**Consultation Response from KC,
Highways Development Management****2023/93087 Land adj, Soothill Hall, 106-108, Oaks Road, Soothill, Batley, WF17 6LT****Erection of detached dwelling (within a Conservation Area)****Date Responded: 5-1-2024.****Responding Officer: Mark Berry.****Responding Ref: 15-8NW-17.**

The proposal is to build a detached 3 bedroomed house with attached double garage on land to the east of Soothill Hall.

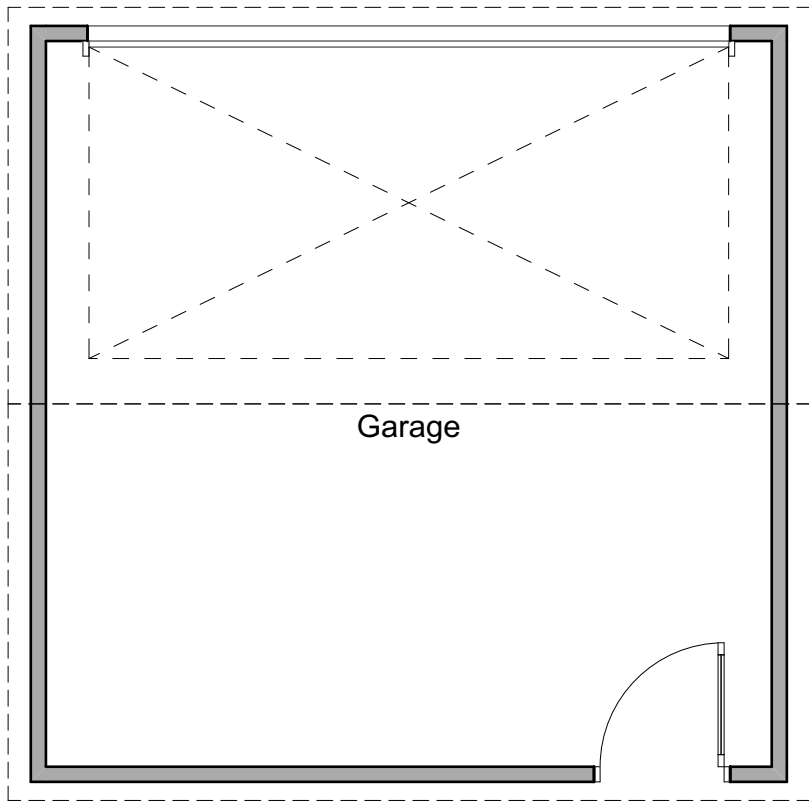
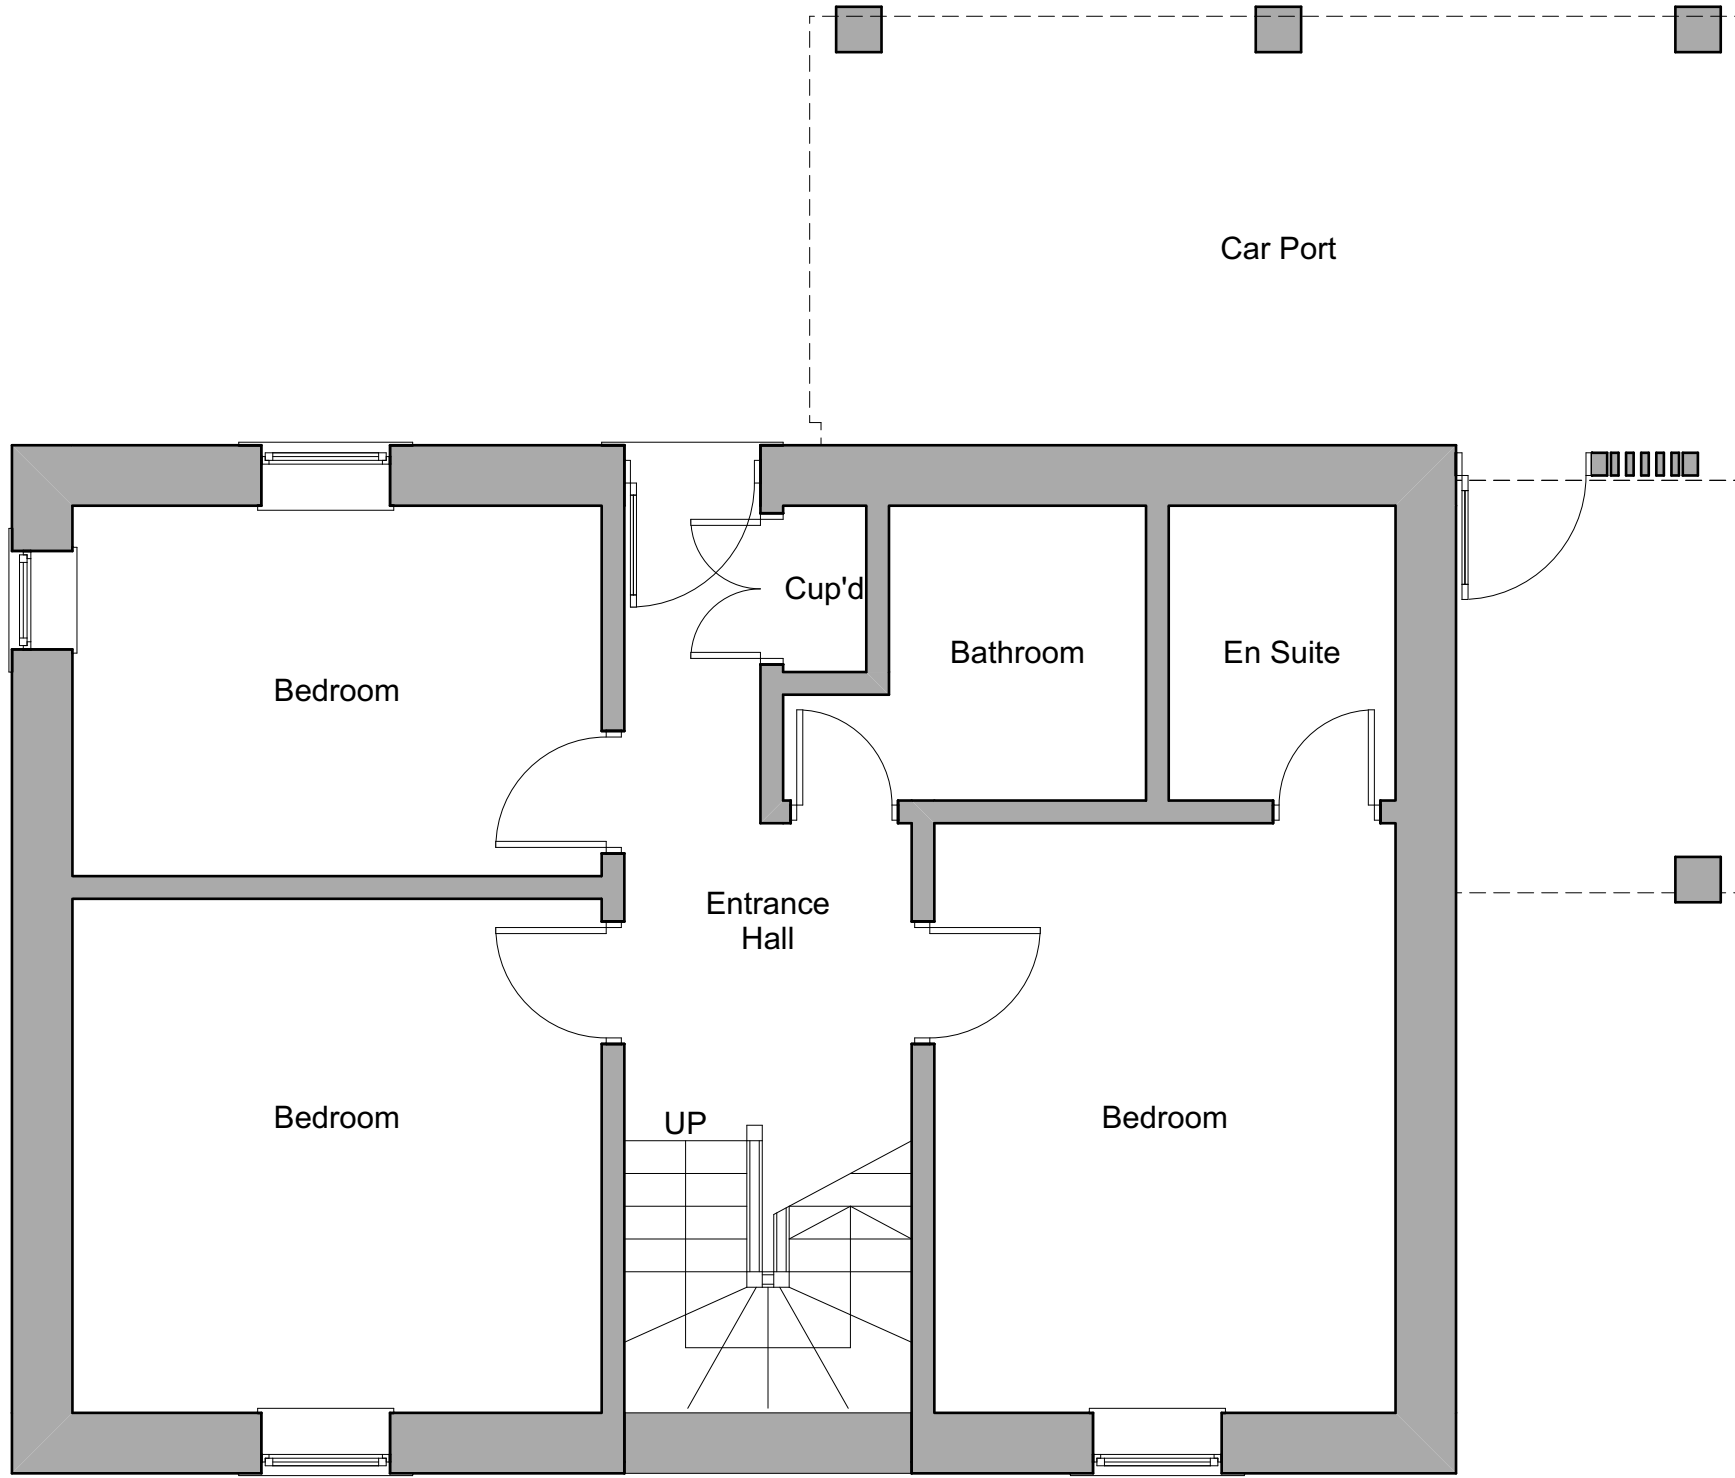
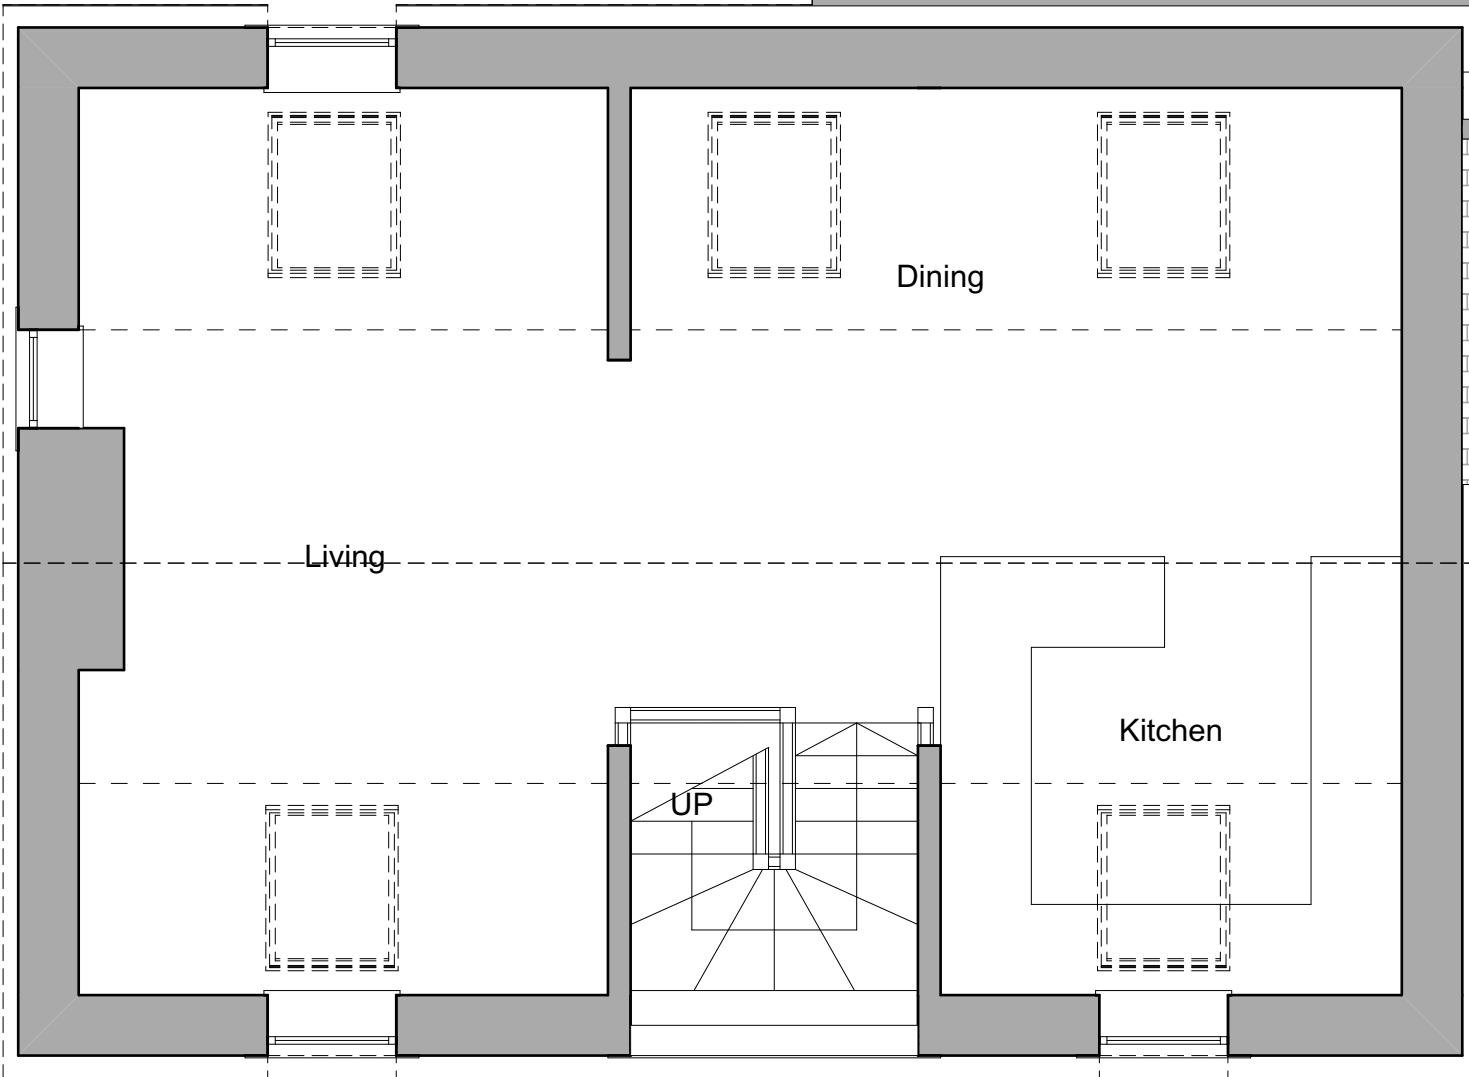
Three off-street parking spaces are shown to be provided, two within the garage and one to the frontage of the proposed dwelling on the private driveway.

Space is shown to be provided to allow internal vehicle turning.

Given that sufficient off-street parking is shown to be provided and the proposals utilise an existing access Highways Development Management have no objection to these proposals.

Prior to the development being brought into use, the approved vehicle parking areas shall be surfaced and drained in accordance with the Communities and Local Government; and Environment Agencies 'Guidance on the permeable surfacing of front gardens (**parking areas**)' published 13th May 2009 (ISBN 9781409804864) as amended or superseded; and thereafter retained throughout the lifetime of the development.
